MMC: FW: Shaws TCP (CMP)

Helen, the following is Shaw Brothers responses to the comments in the email below.

FIGURE  
**2A**

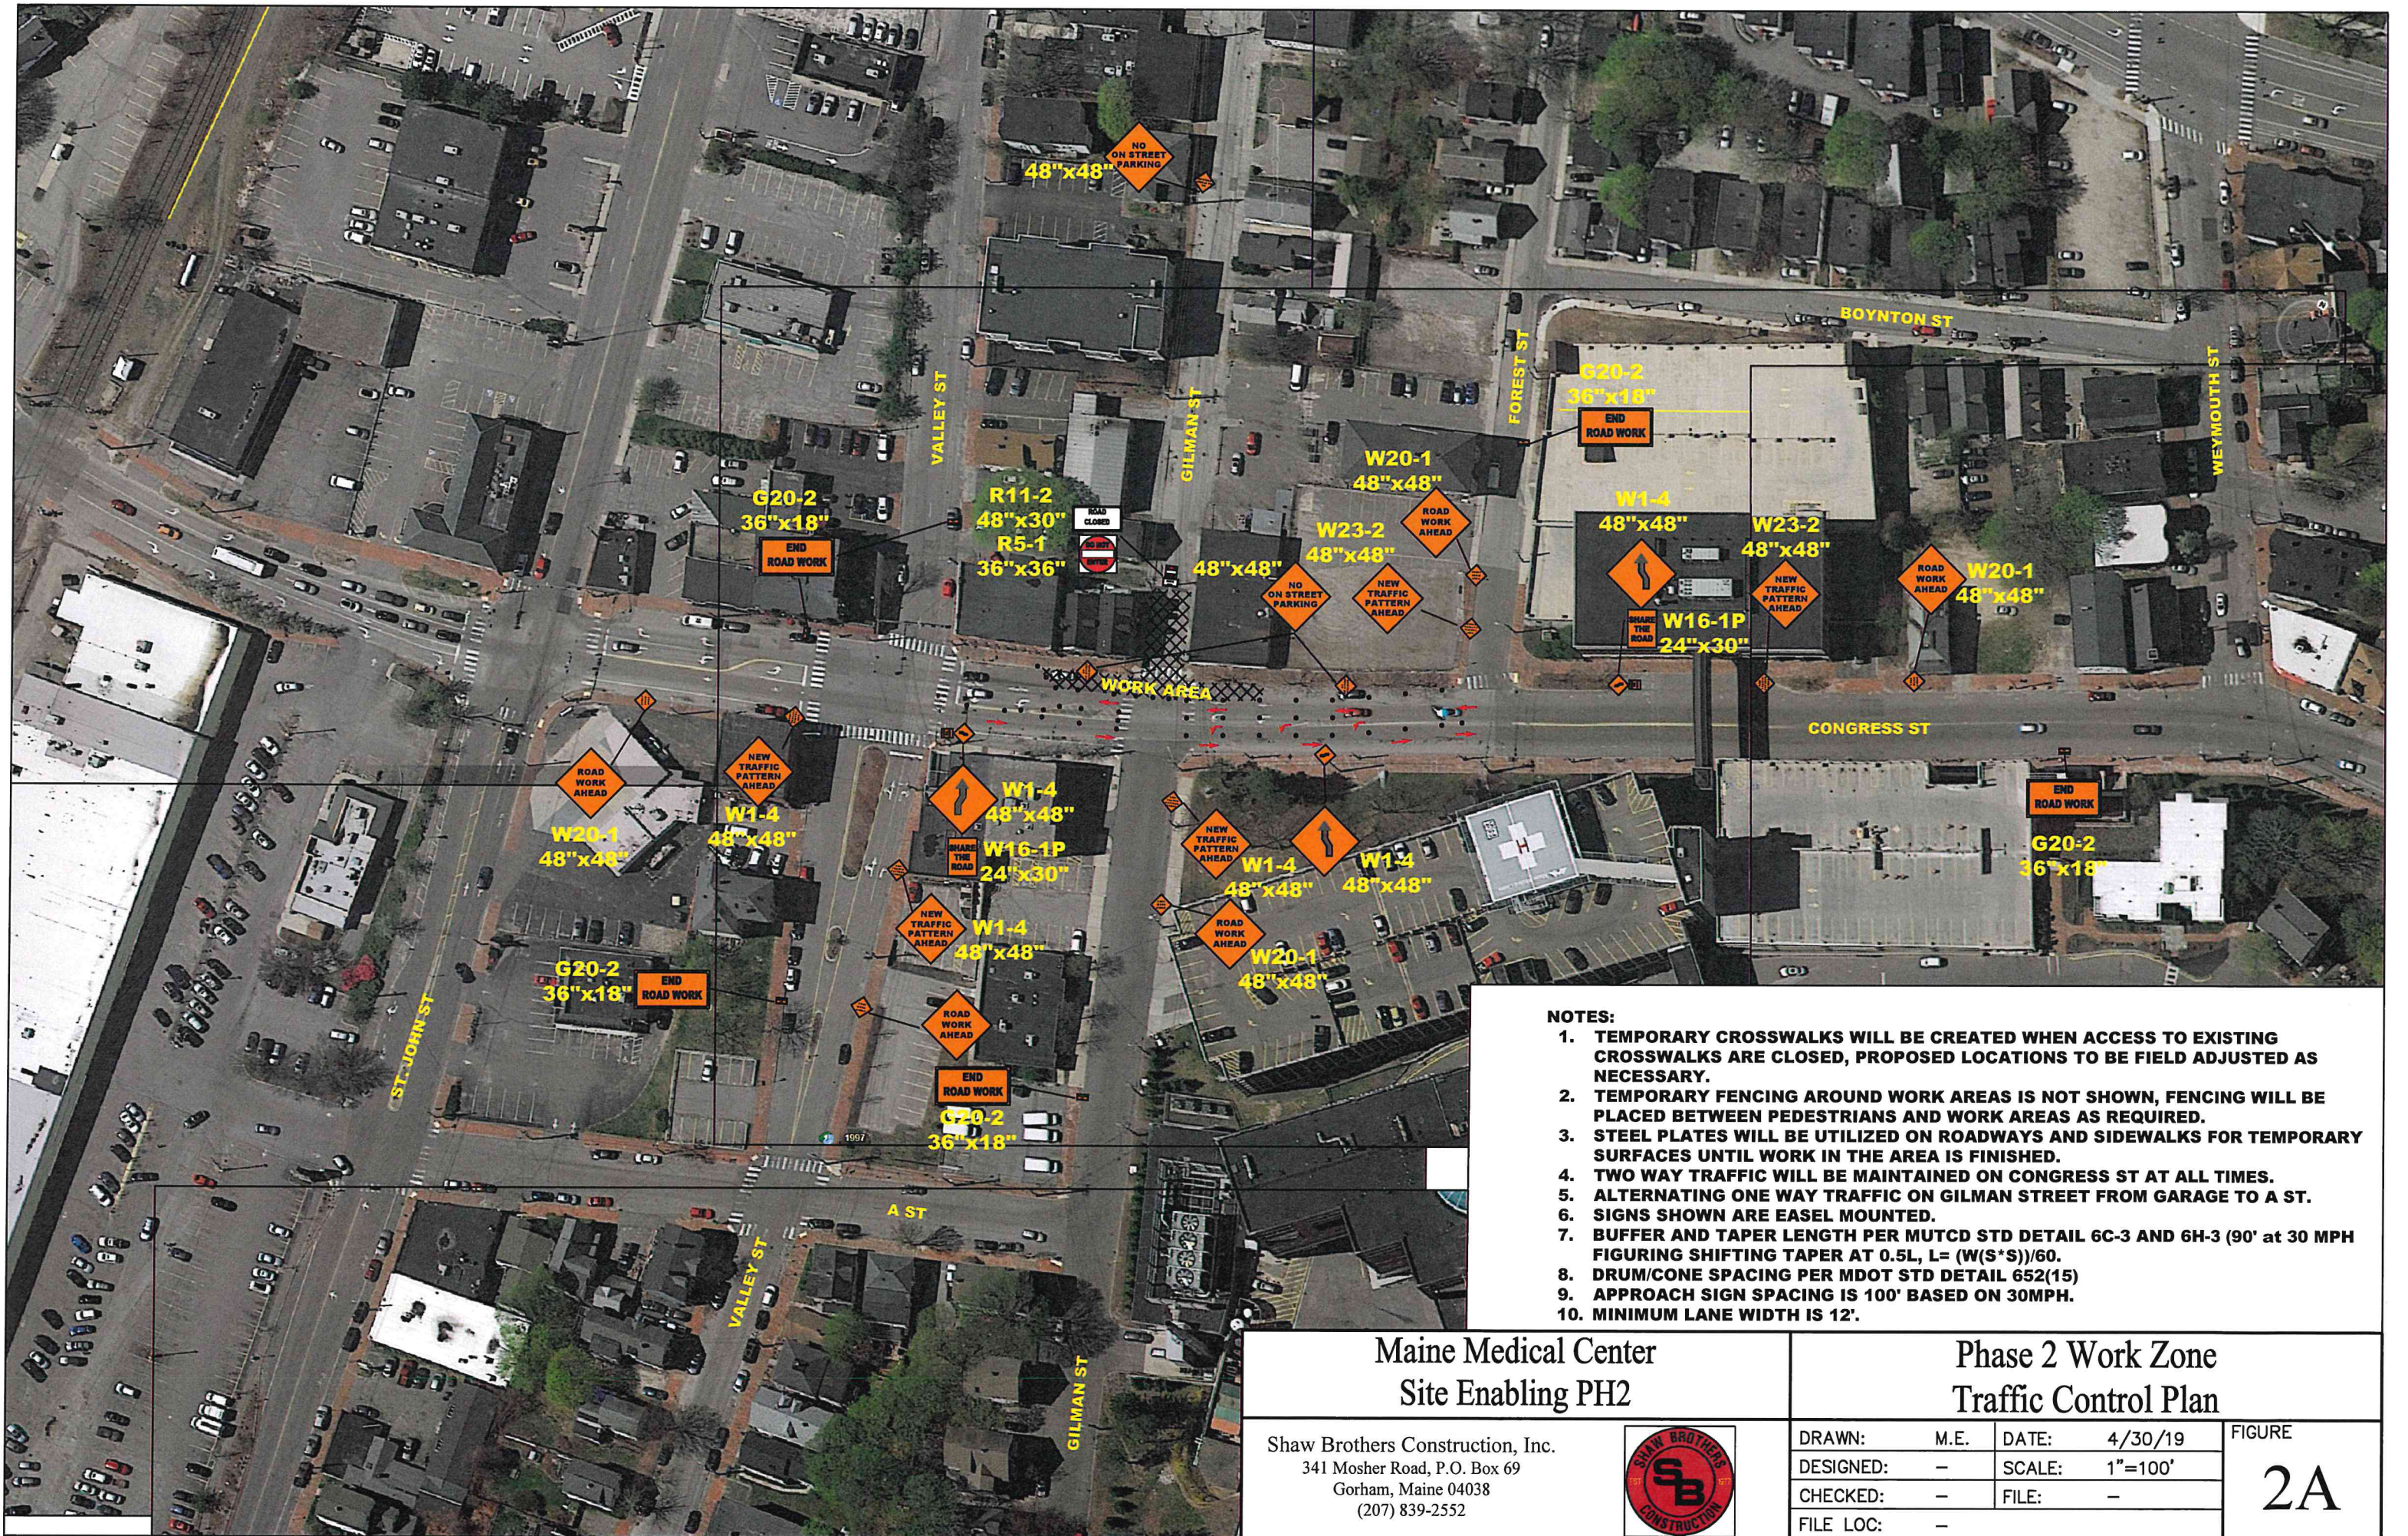
- Conflicting signs will be covered up as needed throughout all phases of work, including the one way sign at Gilman/Park.
- If needed a flagger will be placed at the Park Street end of Gilman Street to help direct local vehicles turning down and exiting Gilman.
- There will be no on street parking on Gilman Street between Park and Congress while during phases 2A and 2A-1. This is because local traffic will need to temporarily travel in two directions in order to exit Gilman Street.
- Deliveries to restaurants should not be impacted. If needed flaggers will assist in directing delivery vehicles through the job site to their destination.
